TOWN & COUNTRY PLANNING (ENVIRONMENTAL IMPACT ASSESMENT)(ENGLAND & WALES) REGULATIONS 1999

REGULATION 19 - SCHEDULE OF FURTHER INFORMATION REQUIRED

BROADWATER ROAD WEST ENVIRONMENTAL STATEMENT, SEPTEMBER 2010

Response to Schedule

05. NORTH ELEVATION

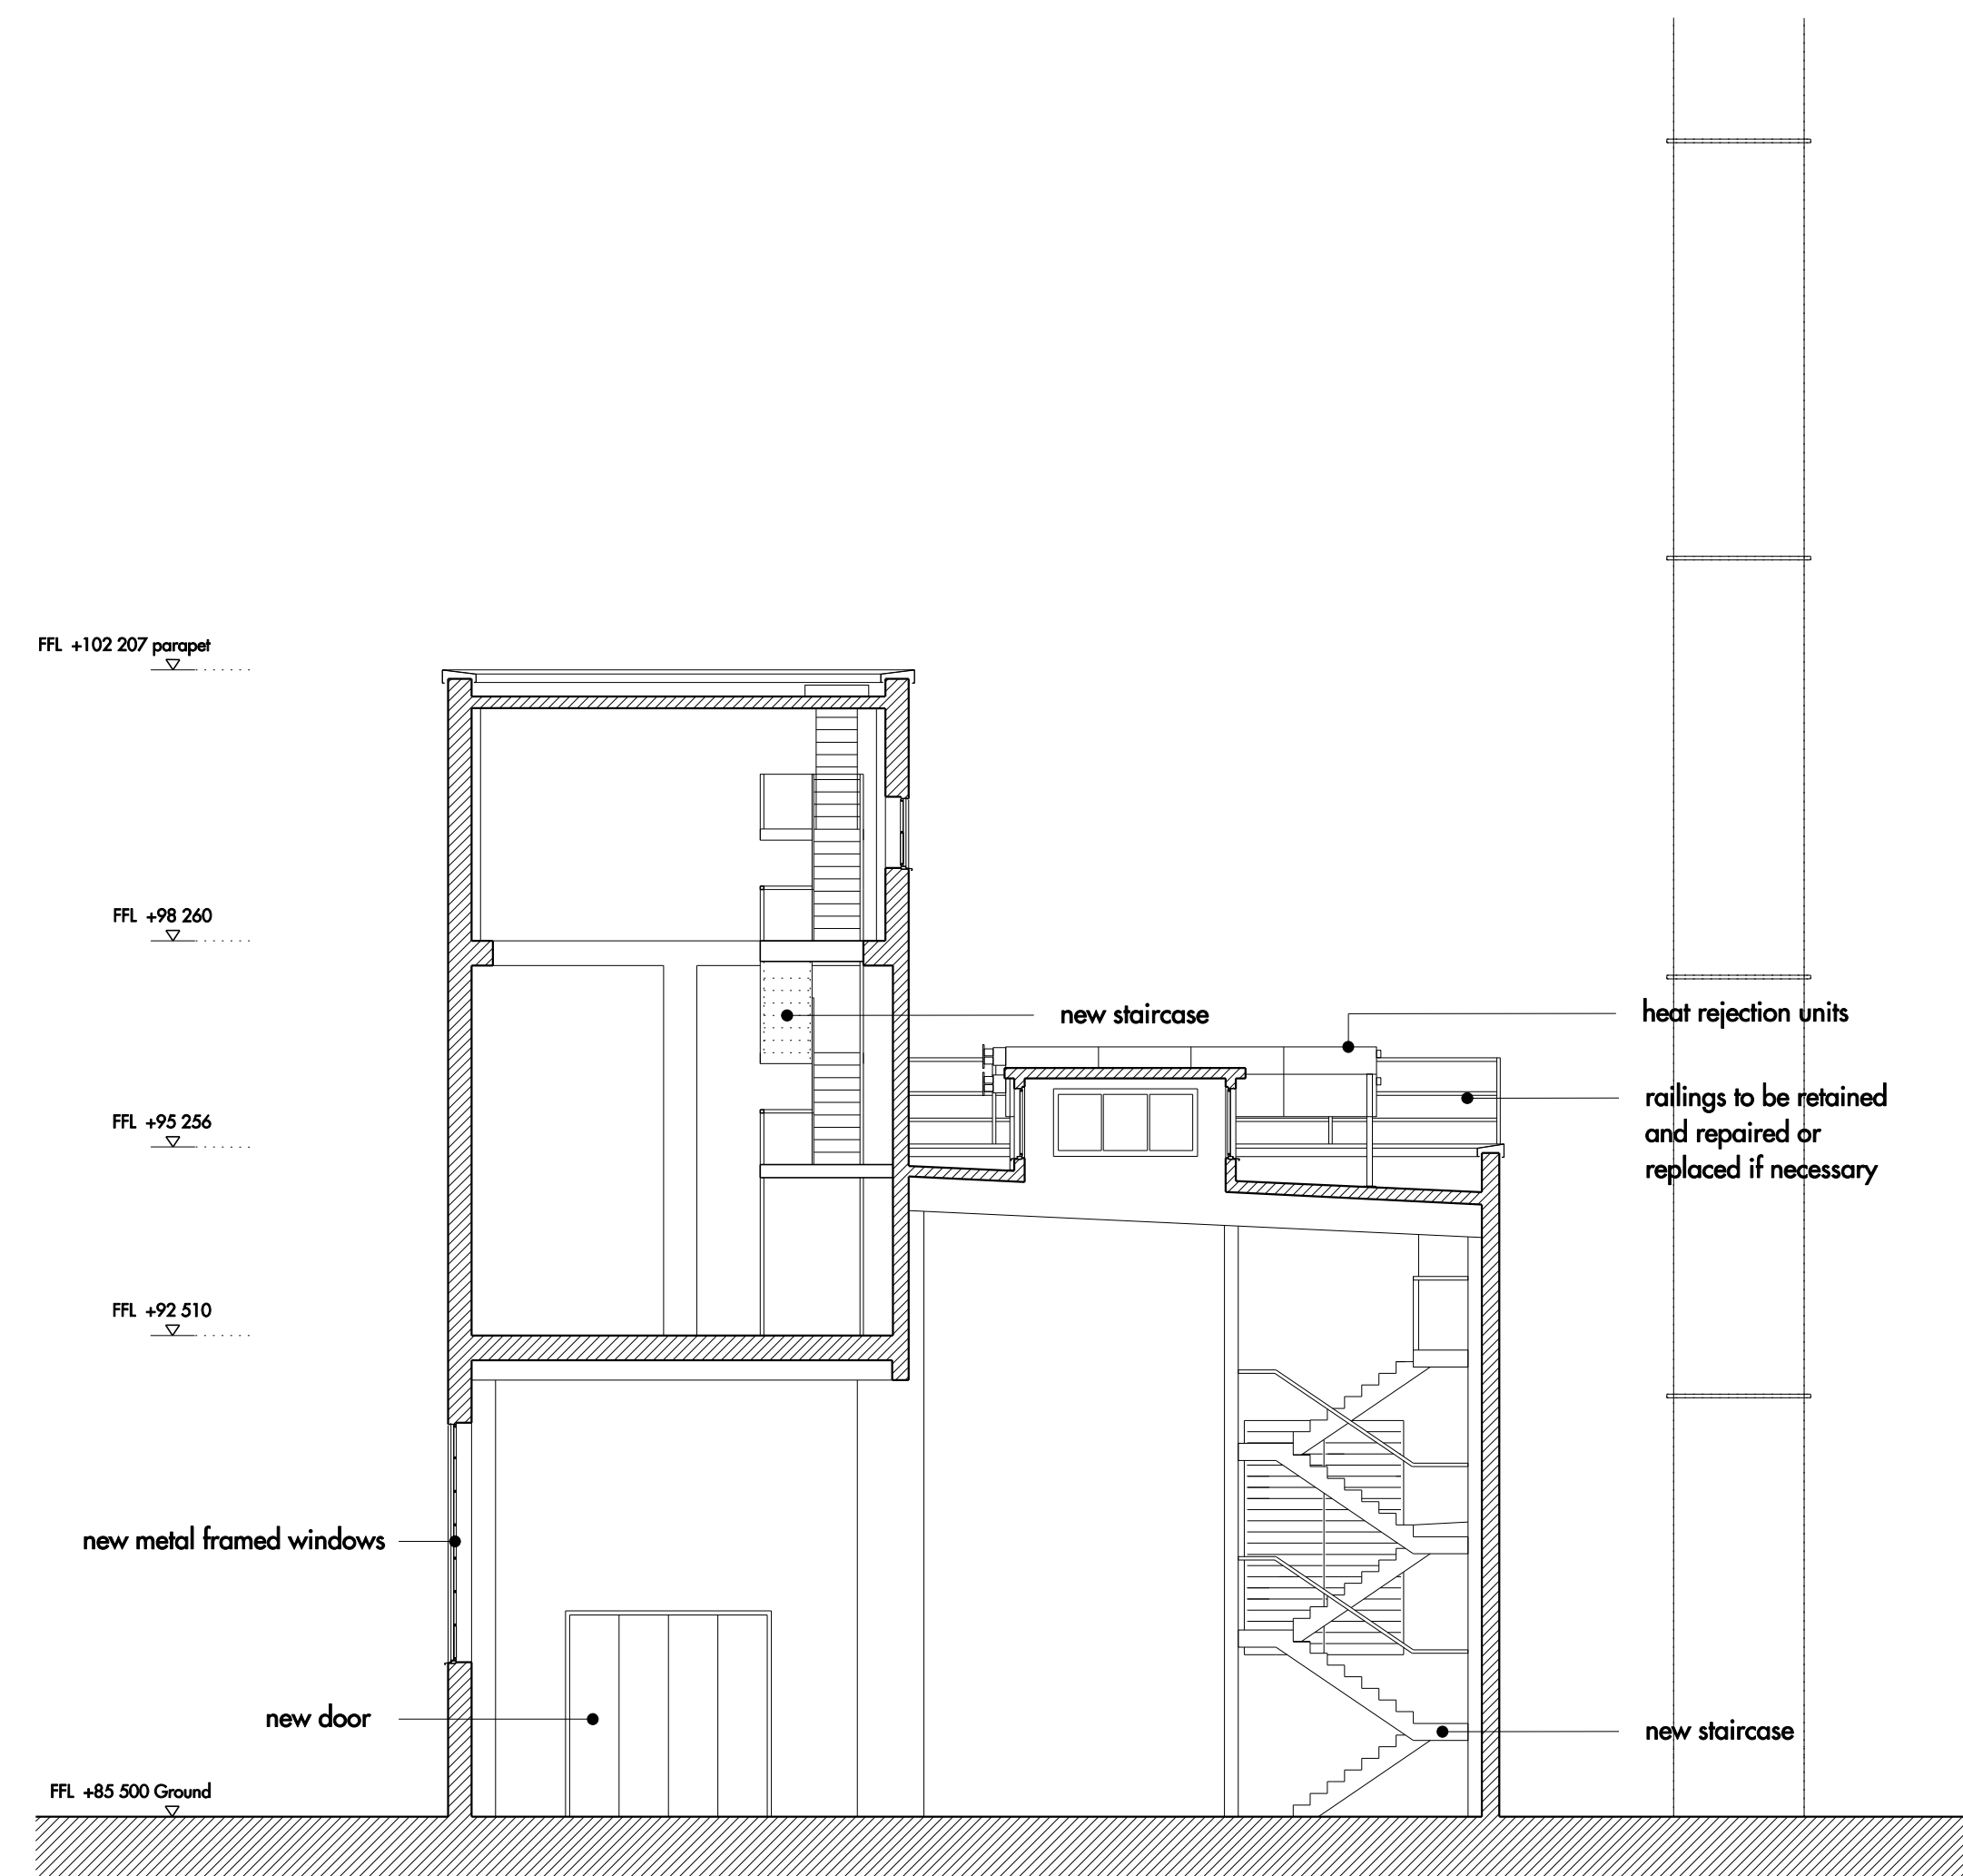
- 2.1 Confirmation is needed on the fuel type proposed for the CHP, and whether or not the CHP will serve the whole development. Confirmation is also needed as to whether the existing building and stack proposed to be re-used for this purpose will be adequate to house all of the plant required. Confirmation should be provided of the air quality, noise and visual impacts that will result from the CHP, as nearby residential units and other uses which may be adversely affected by the CHP lie within the area of the detailed application.

The energy strategy and statement (Part C Appendix C) has been updated in conjunction with the scheme description to make it clear that the existing boiler house is to be used to house the energy centre for both detailed and outline application

areas, and that the existing stack will be re-used, to incorporate new internal gas flues for the gas-fired CHP plant. The energy centre is fully considered the environmental topic impact assessments
